Erection of restaurant/café/bar, six guest rooms, exhibition room, wcs, terrace, car parking and ancillary accommodation at Castle Hill

The following comments are objections to the present application due to **its statutory status as a scheduled ancient monument located within the green belt and which is additionally within the curtilage of a listed building and a site with significant ecological value.**

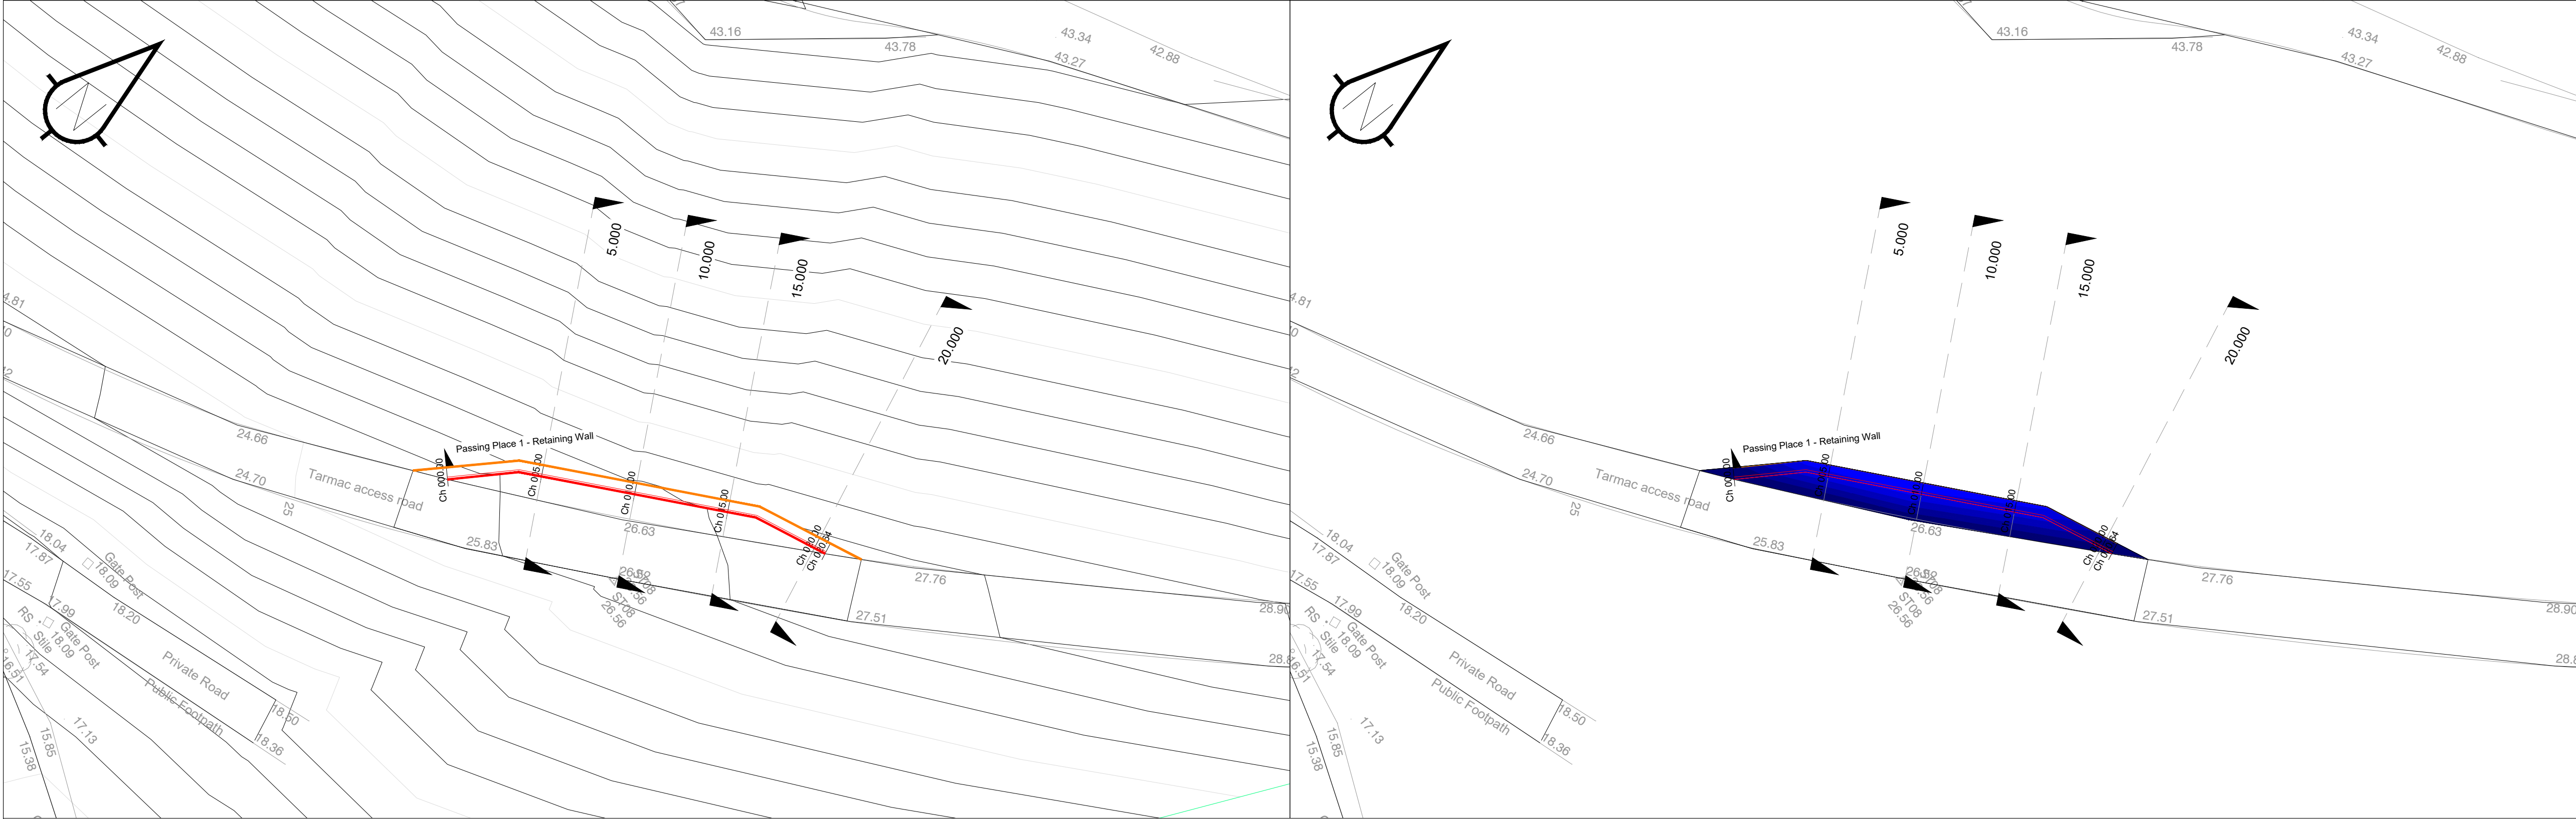
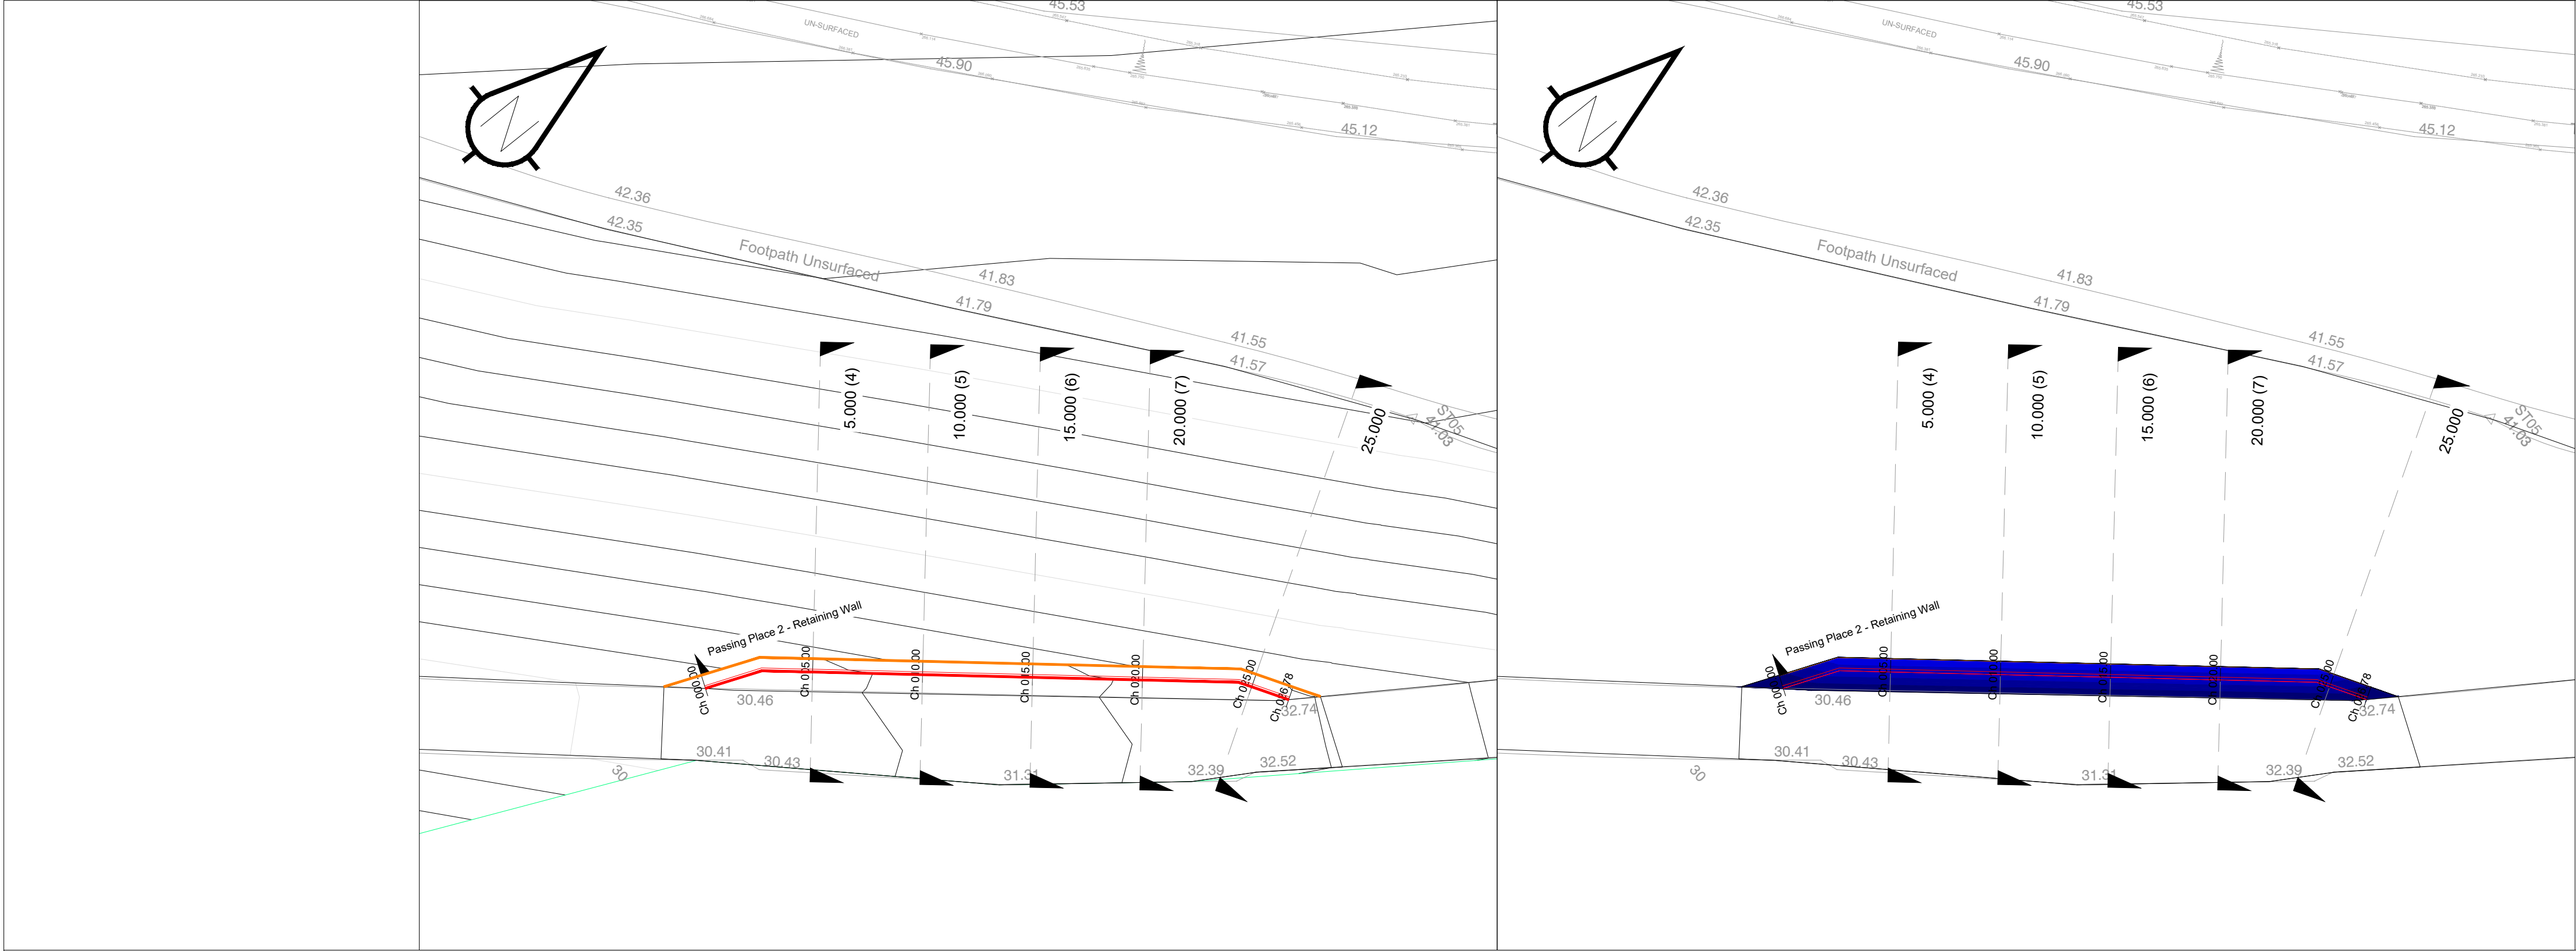
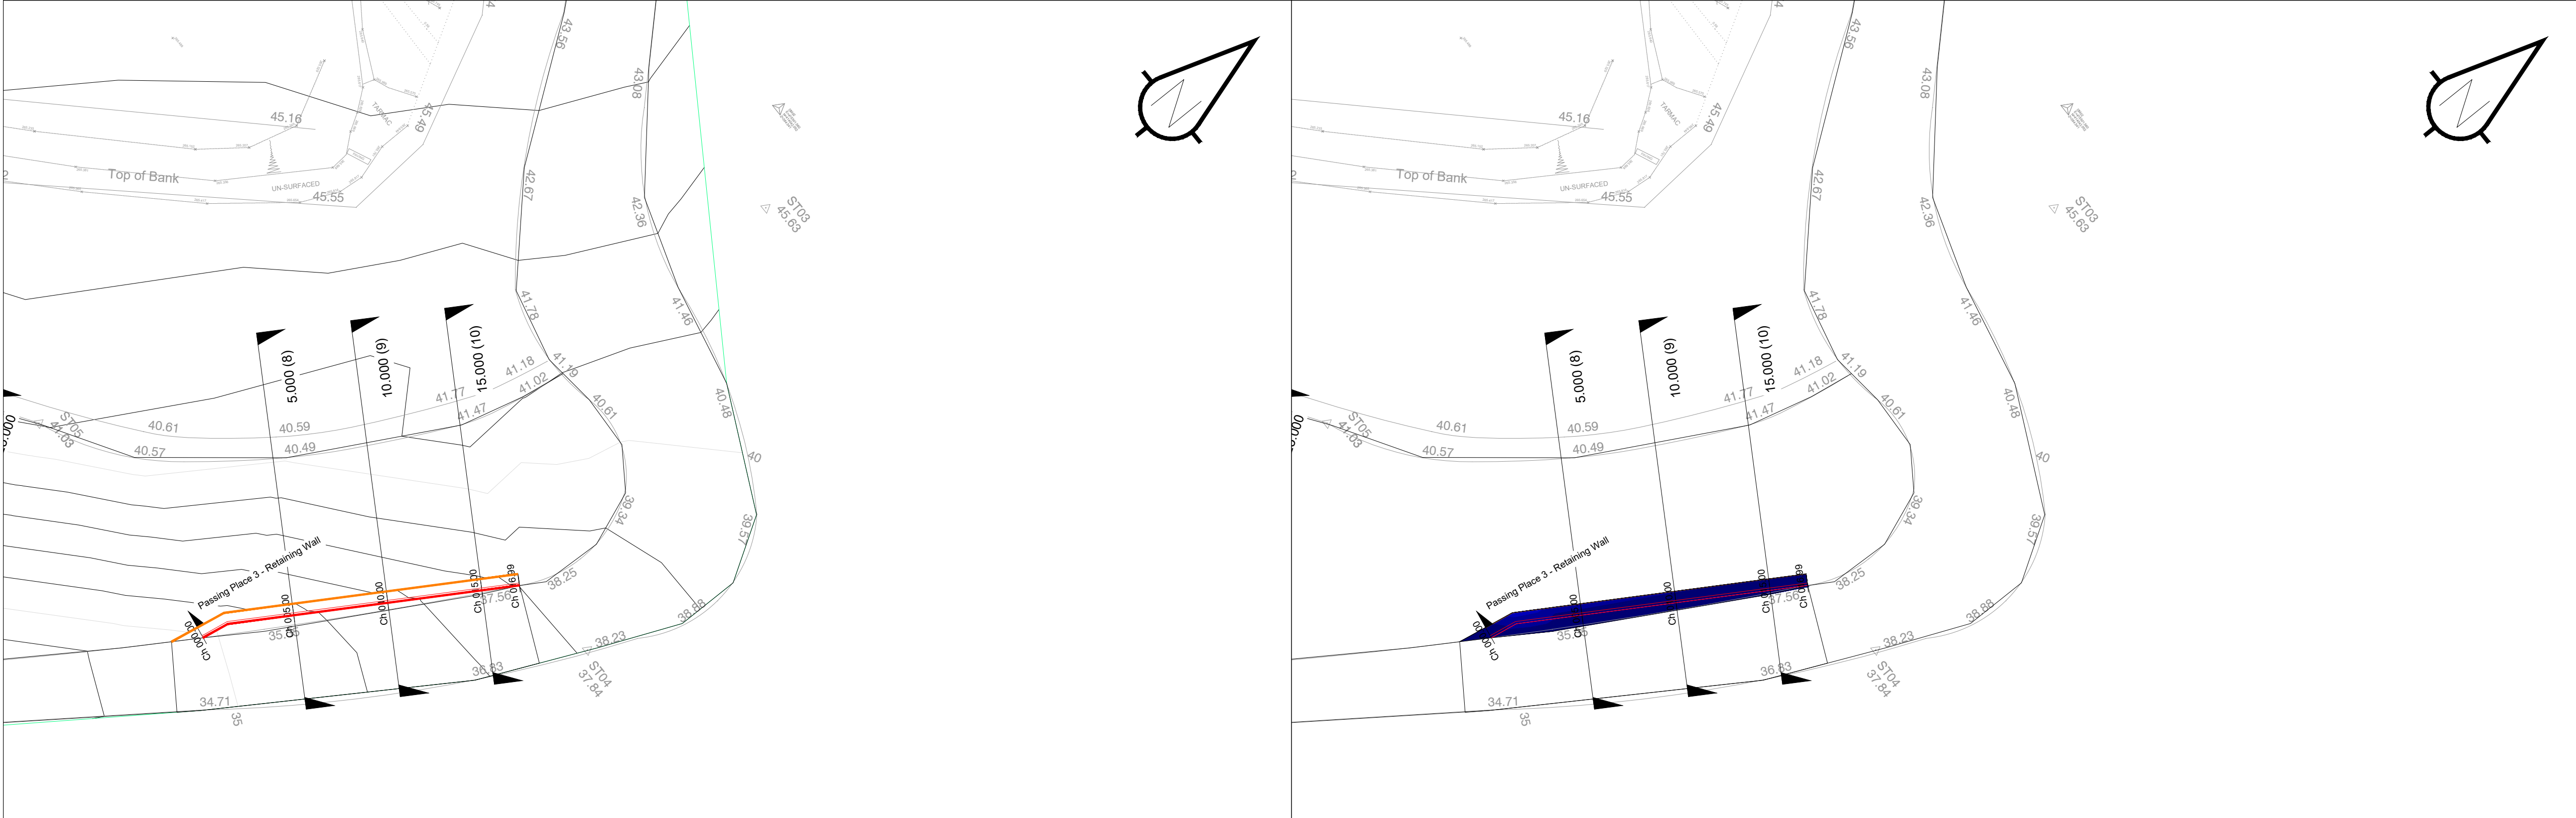
As noted above vehicular access to the top of the hill is limited and constrained by the tight bends in the road. The proposal to include passing places will do something to aid access (for private cars) but this solution does not seem to be a sustainable one in the long term due to the possibility of further erosion of the earthworks and the impact of large vehicle movements. There is no consideration of how increased vehicle access to the hill, particularly by delivery / refuse and other large / HGV vehicles which now rarely use the access road will impact on the wider road network or of traffic management issues in the local area.

Proposed South Elevation 1:200

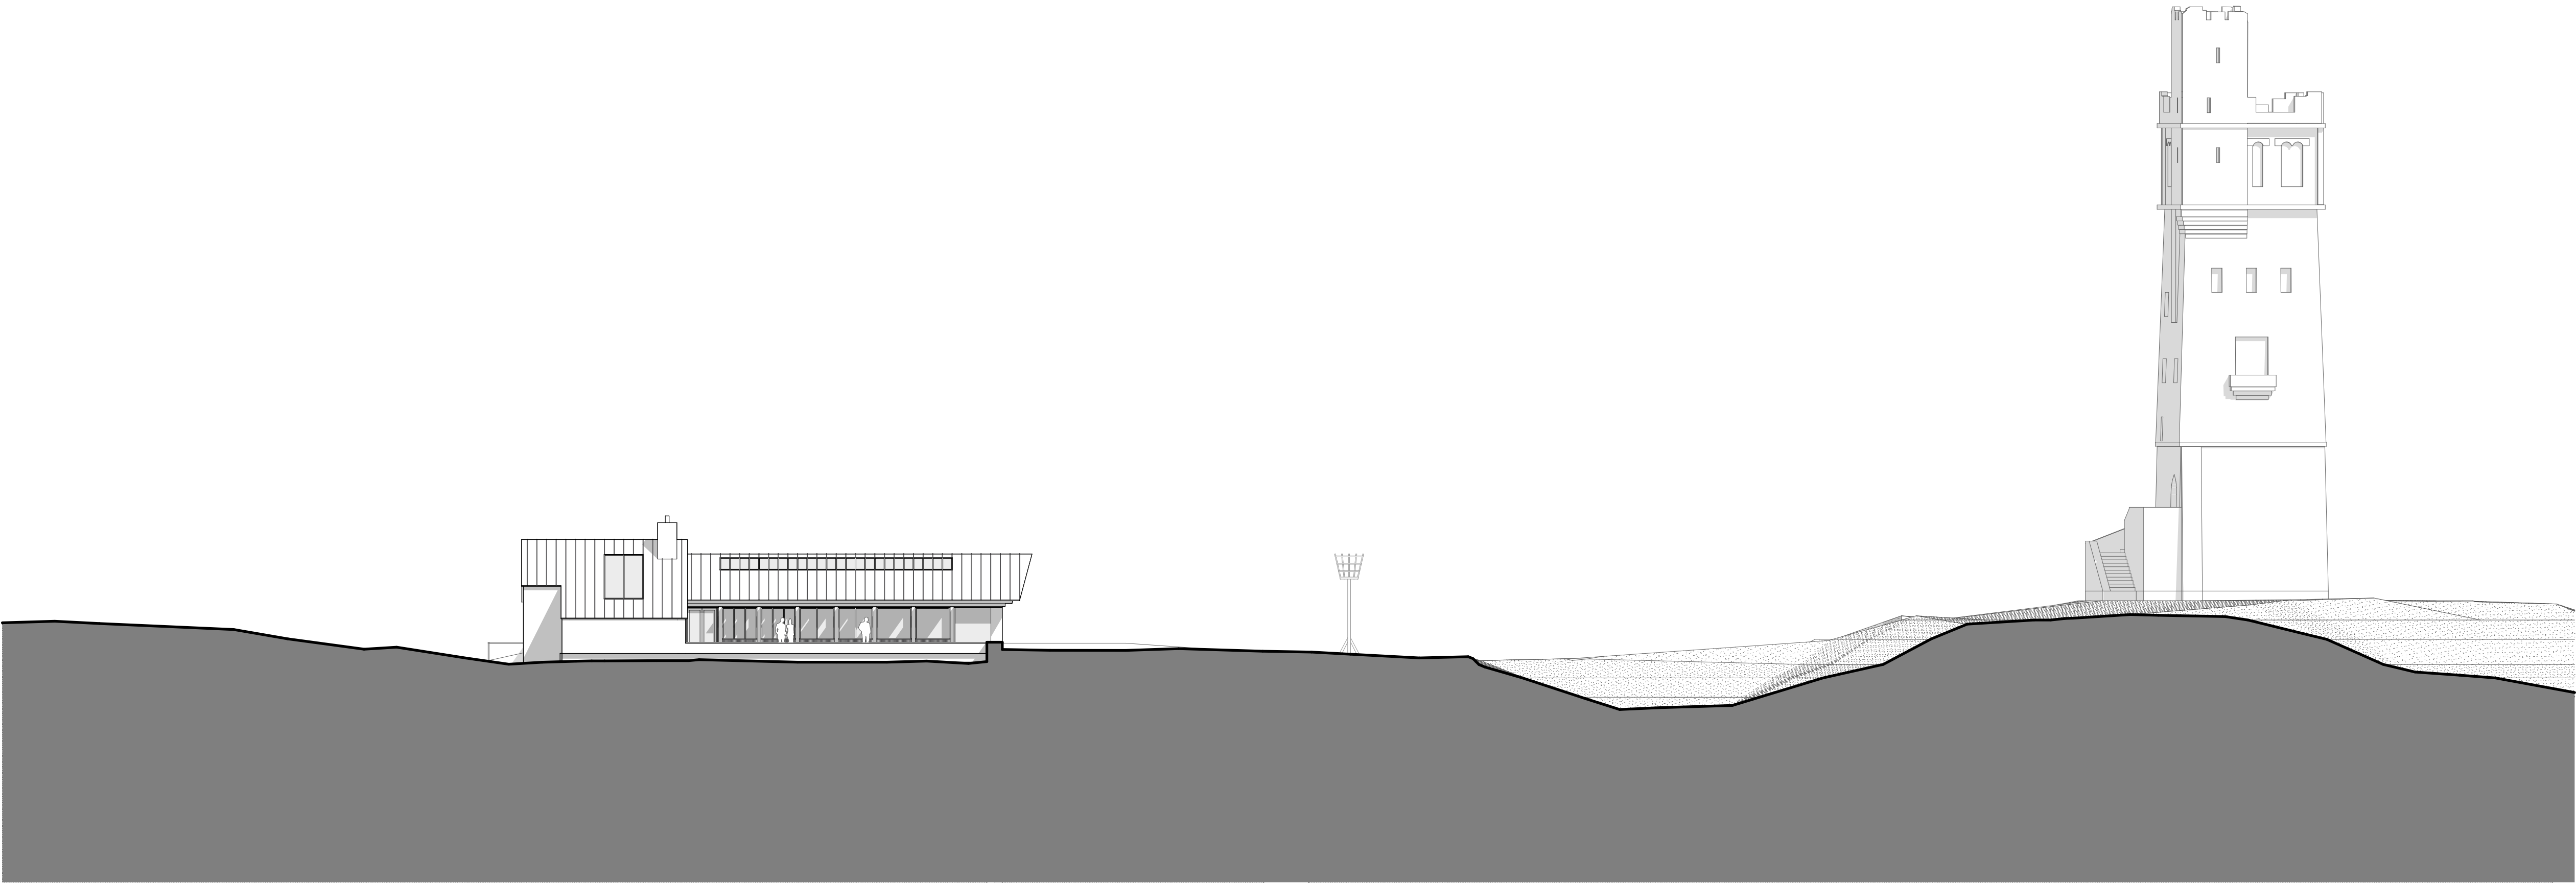
- There is no indication of how the open service area will be treated what of the need for bin storage, secure gas storage etc these are not shown at all, all such intrusive elements will be visible from afar. Indicative 3D view 1 does not show any detail here (or the proposed gate across this area – will it be manual or electrical operation?)
